WEST SUSSEX COUNTY COUNCIL CONSULTATION

TO:	Arun District Council FAO: Maria Tomalova
FROM:	WSCC - Highways Authority
DATE:	21 January 2022
LOCATION:	1 Spencer Street Bognor Regis PO21 1AP
SUBJECT:	BR/277/21/PL Conversion of office building into 2 No 1 bedroom dwellings. This site is in CIL Zone 4 (Zero Rated) as flats.
DATE OF SITE VISIT:	n/a
RECOMMENDATION:	Advice
S106 CONTRIBUTION TOTAL:	n/a

SITE PLAN(1:200)

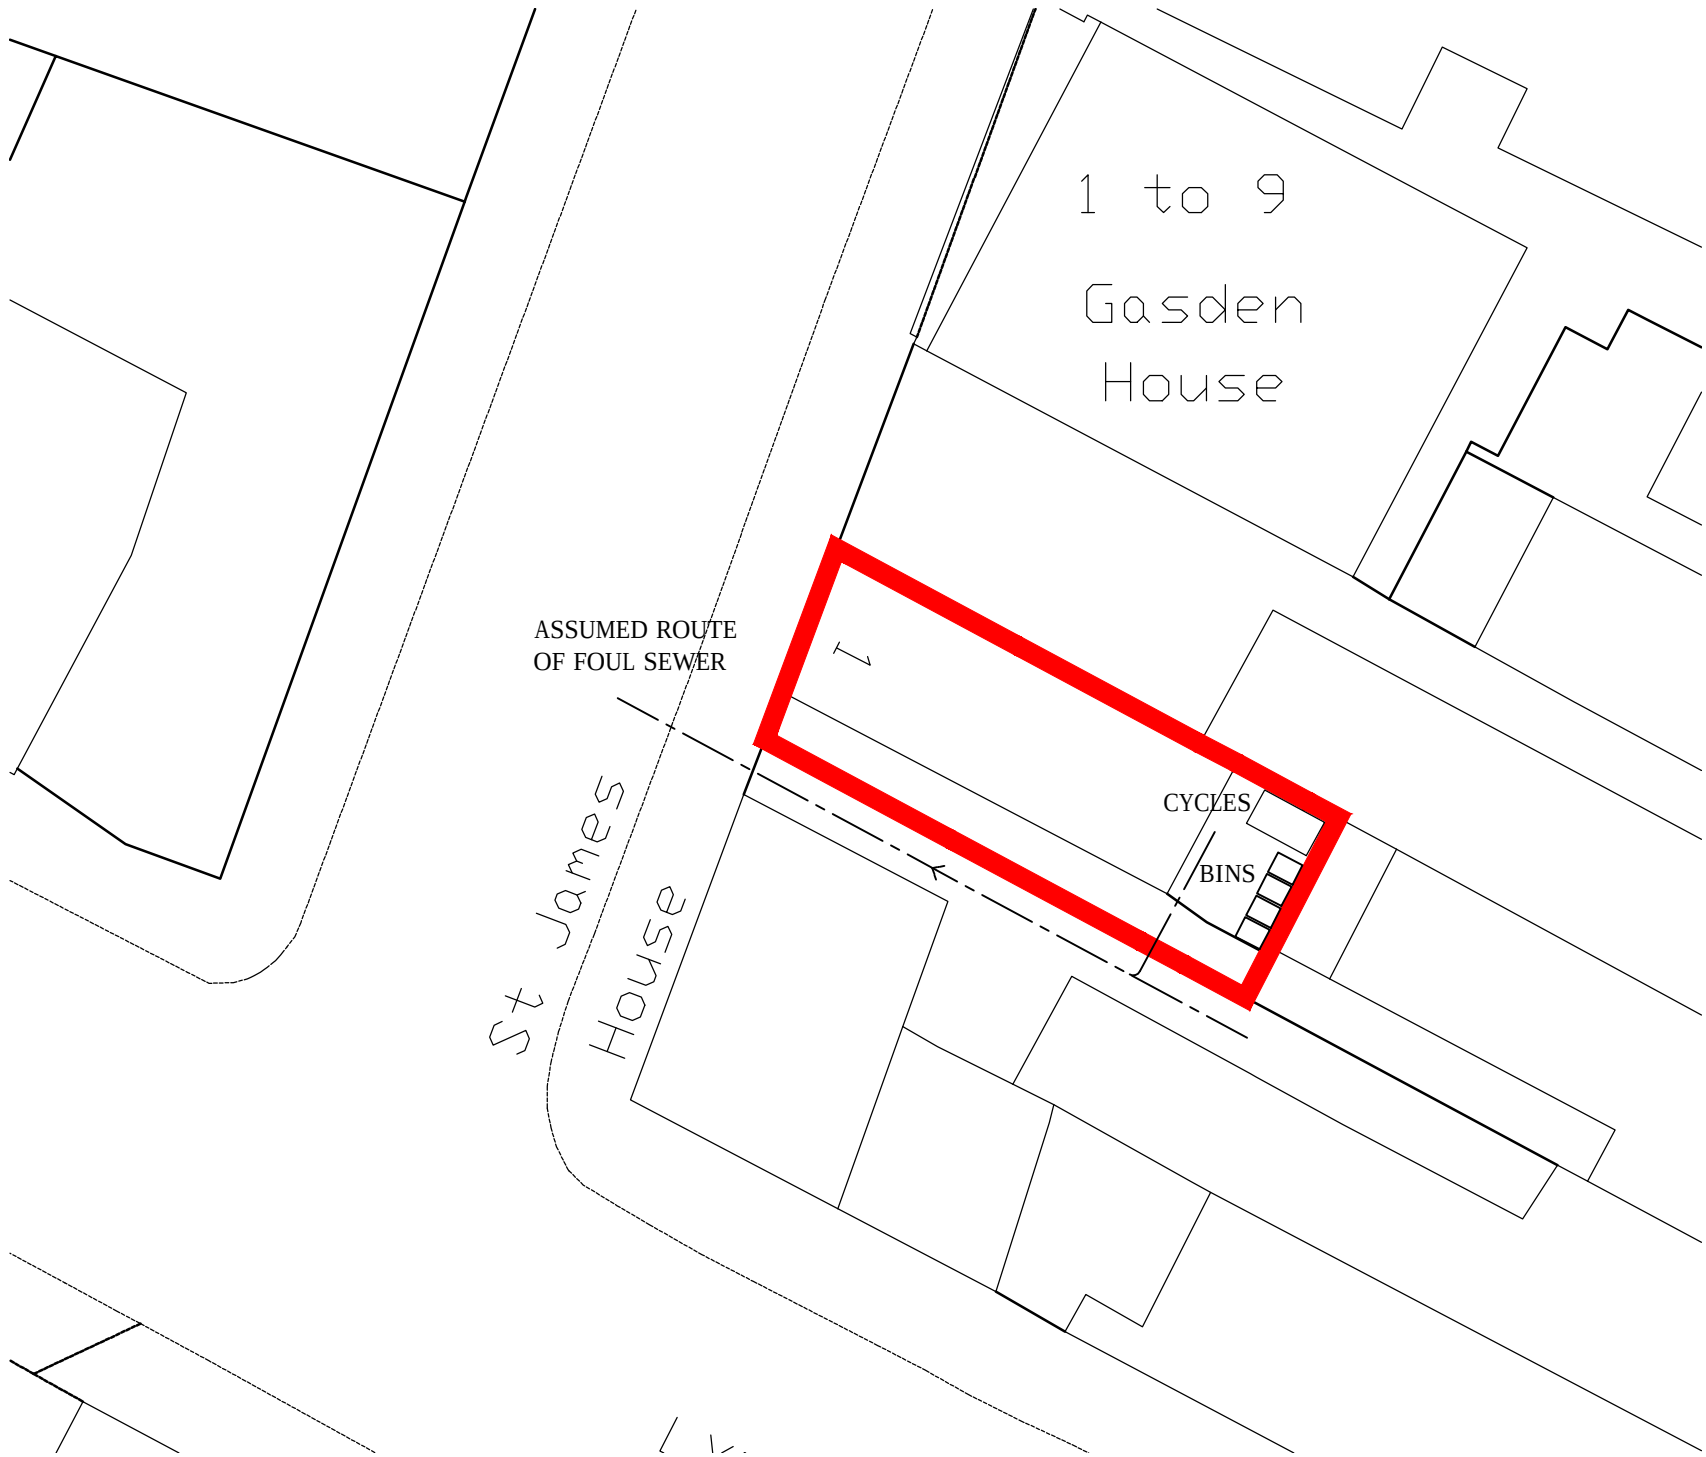
The proposed site plan demonstrates cycle and bin storage to the rear of the site within a courtyard. Cycle storage should be secure and covered and any shared cycle storage facility should provide Sheffield stands within, to enable residents to secure their cycles. Details of cycle storage can be secured via condition.

Cycle parking

No part of the development shall be first occupied until covered and secure cycle parking spaces have been provided in accordance with plans and details to be submitted to and approved by the Local Planning Authority.
